**From:** [White, Lori \(FCY\)](#)  
**To:** [Kelly Bacon \(GD\)](#)  
**Cc:** [Lindsay Ozbohl](#)  
**Subject:** RE: SX-19-00018 - Daniels Wetland Biologist Report  
**Date:** Friday, December 6, 2019 1:25:12 PM  
**Attachments:** [image001.png](#)  
[image002.png](#)  
[image005.png](#)  
[image007.png](#)  
[image008.png](#)  
[image010.png](#)  
[image013.png](#)  
[image014.png](#)  
[image015.png](#)  
[image016.png](#)  
[image017.png](#)  
[image018.png](#)

I have reviewed Mr. Sewall's report and I am not convinced the wetland is from irrigation. Historical images from 1954 show the area to be connected to Naneum previously, and consisting of side channels (Image 1, 2, and 3; approximate area of interest is outlined in red). Topographic features or the old channels can be found in Lidar imagery (Image 4). It is currently located outside the Creek's floodplain. There is likely still some subsurface connection occurring, as the wetland appears to be part of a larger complex this should be evaluated further.

Above: Wetland and stream map of study area.

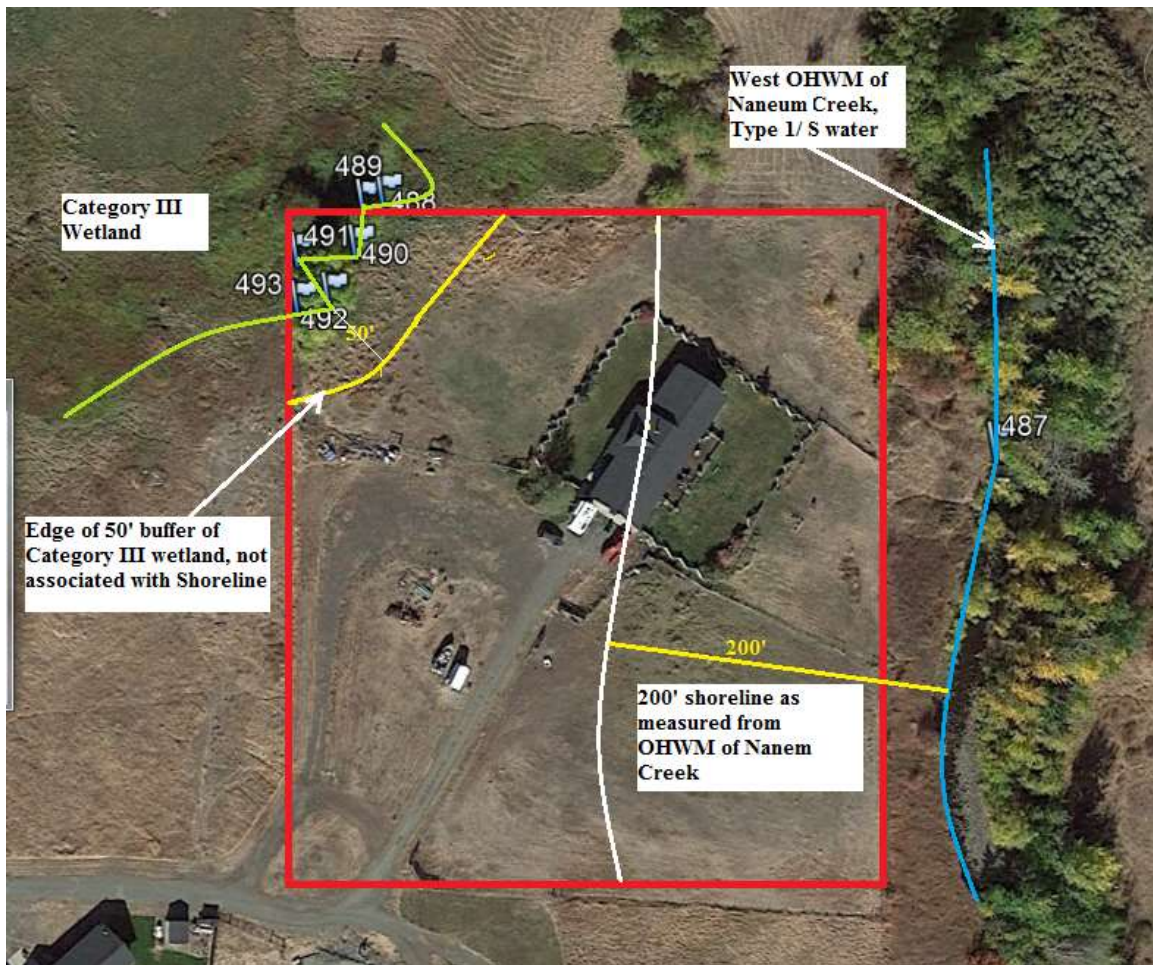
In addition, I believe some other areas on the parcel should be investigated for potential wetland habitat and any offsite but adjacent wetlands should be rated. The area, that is now a drive way appears to have previous wetland signatures based on the desk review I have conducted. IF the wetland is still connected to the southern lobe (Image 5), as it once was, it would be influencing/influenced by the creek and therefore considered shoreline. Mr. Sewall did not provide evidence that he investigated areas outside of the NW corner of the property. The investigation was conducted in early November, once the vegetative growing season was over and seasonal variations were not present. If grazing is not year round, it would be helpful to revisit the site in the spring.

Additional investigation and information is needed to determine if it is a shoreline wetland. The hydrologic regime, including frequency, extent and duration of flooding of Naenum Creek should be discussed and evaluated in the report. Feel free to contact me should you have any questions or would like to discuss the comments below.
